# BUILDING B - NORTH-EAST CORNER CONDITION

STAGE 1A - RTS3 ADDENDUM

TELOPEA RESIDENTIAL - STAGE 1A  
COUNCIL PRESENTATION

JOB NO. 20320  
DATE 13/12/2023  
SCALE NTS

DRAWING TITLE
**LOWER GROUND FLOOR
PLAN**

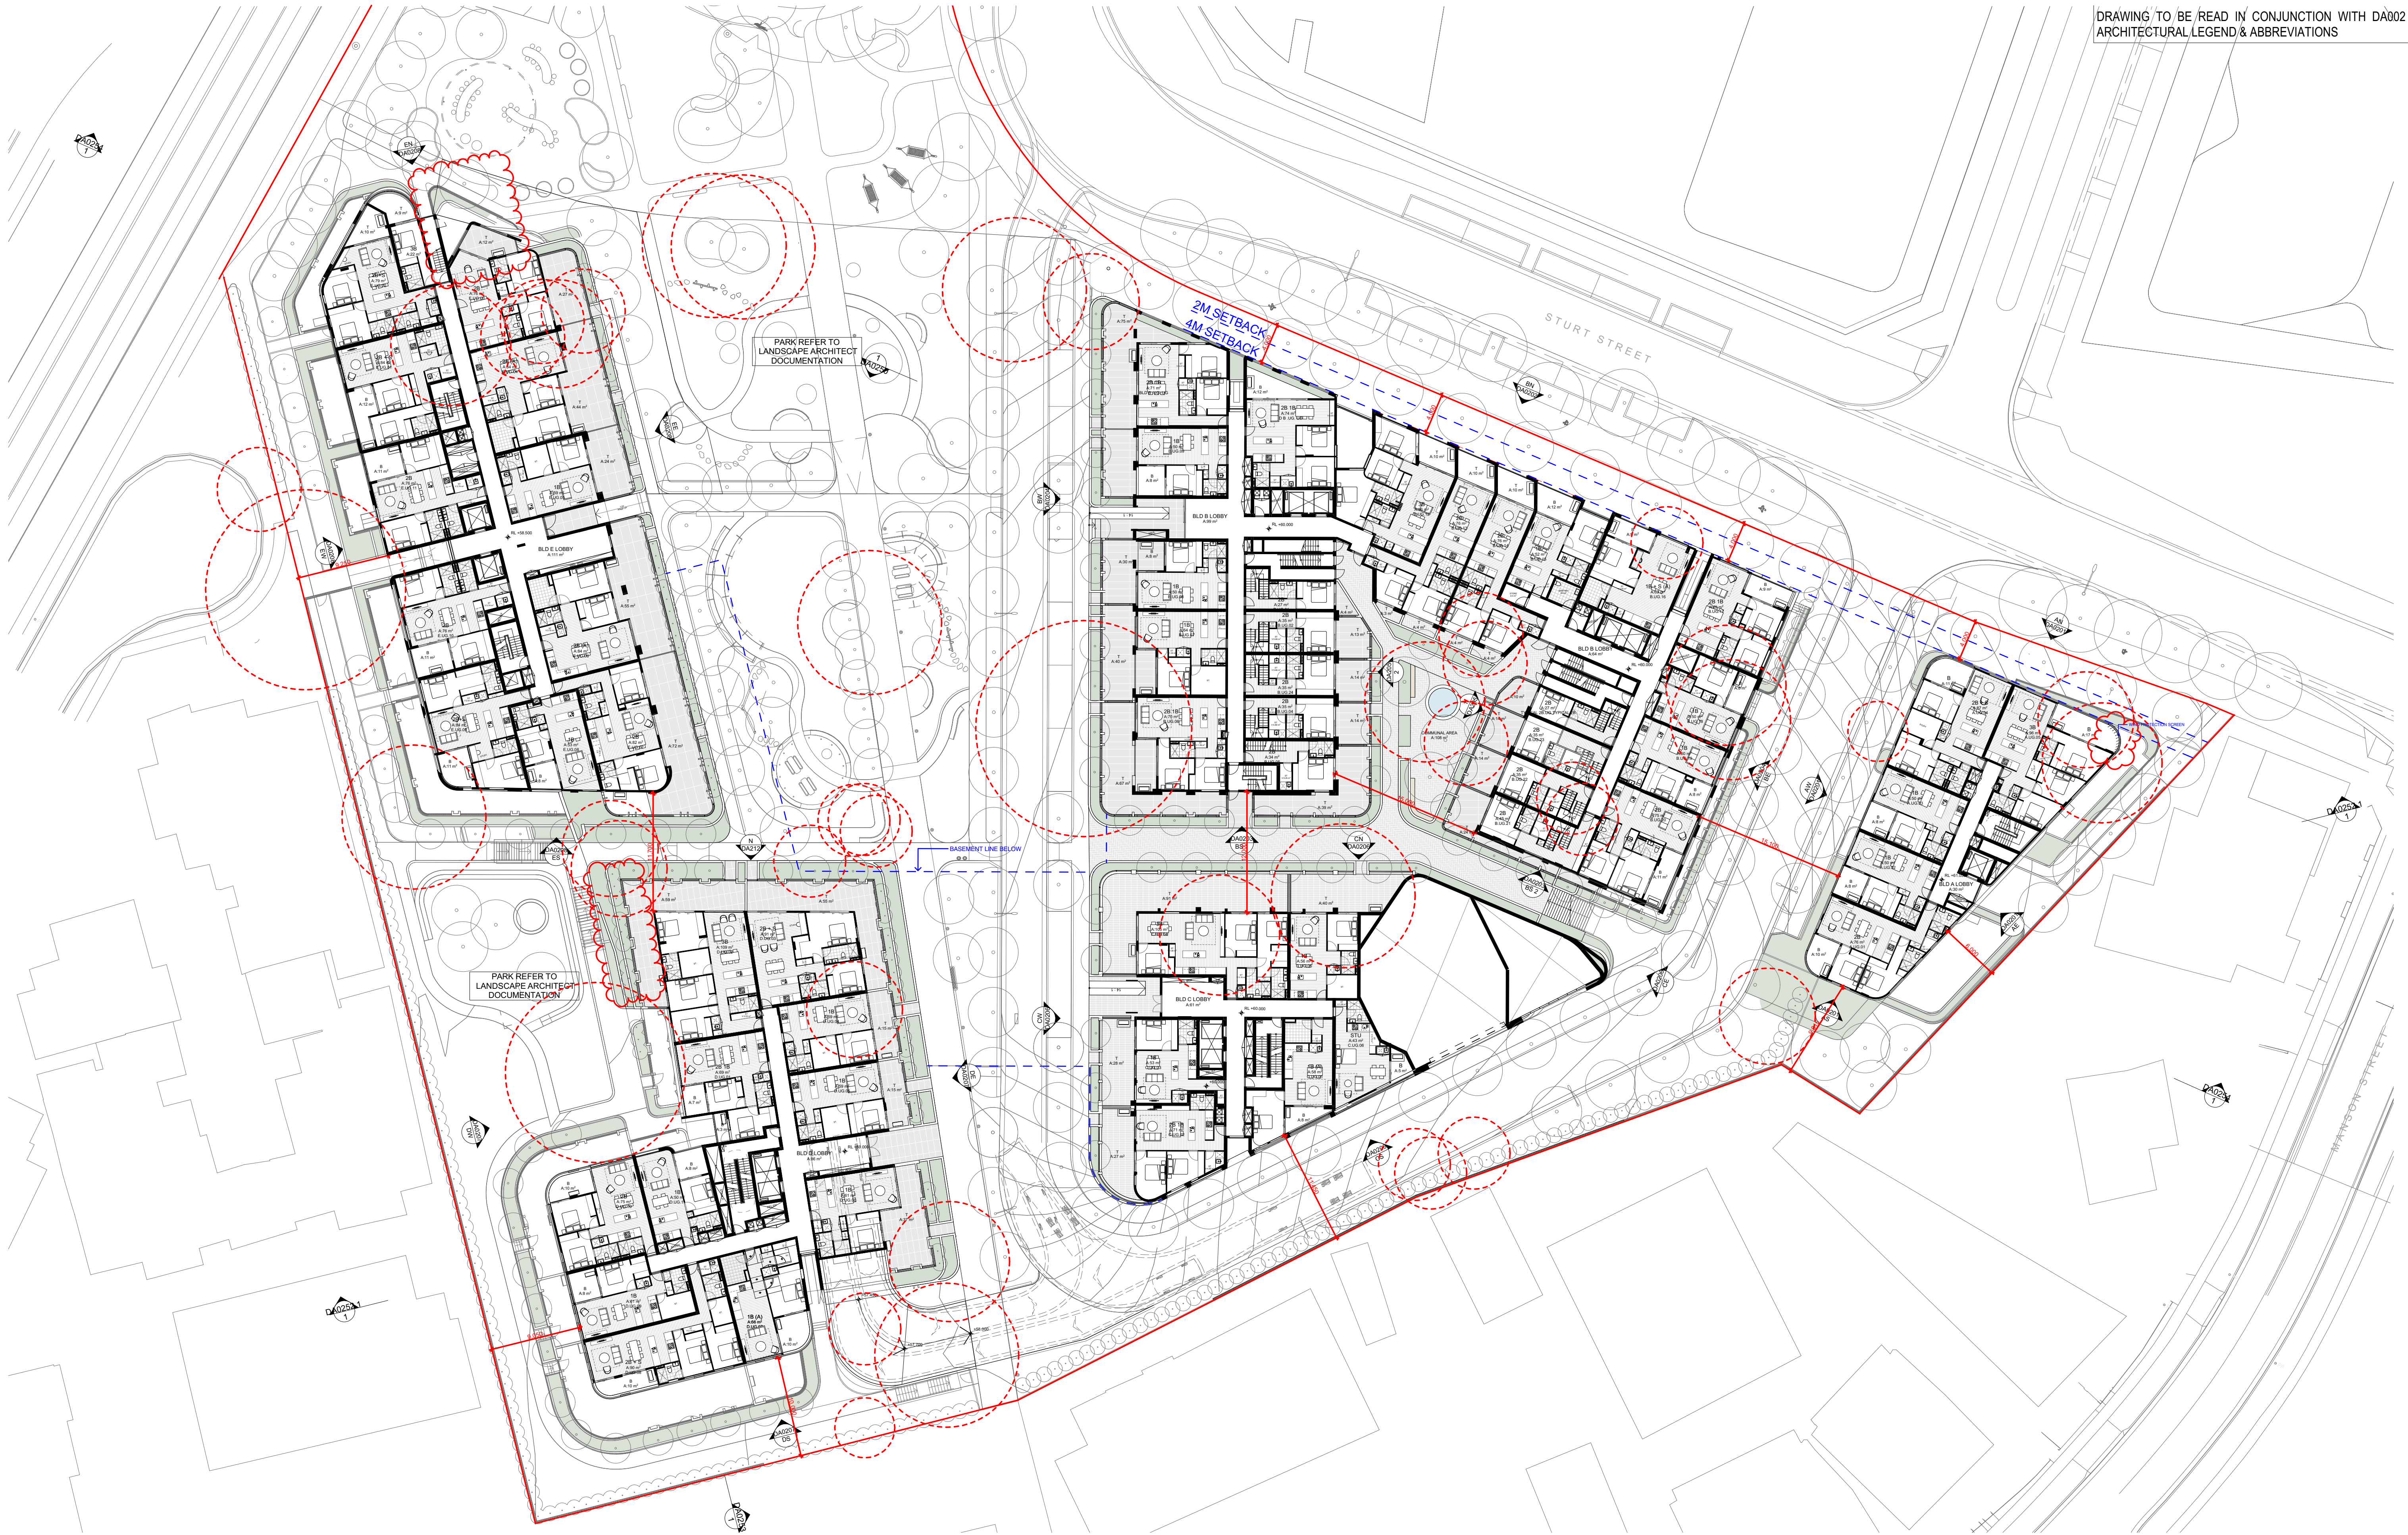
The ground level setback along Sturt Street should be a minimum of 4 metres and be **free of basement structure in order to establish thriving trees and landscaping.**

- a.) Setback of ground levels, 4m setback to facade/private open space line including a metre of planting buffer to ensure privacy screening. 3m of private open space on ground levels will still be achieved (ADG).
- b.) 1m of landscape planting has been provided across the podium to further increase visual privacy.
- b.) Minor amendments to mix/yield, GFA reduced.
- c.) Removed previously proposed unit from building A (basement 01)
- d.) Basement structure remains within 4m setback - ensures 4m of clear deep soil planting.
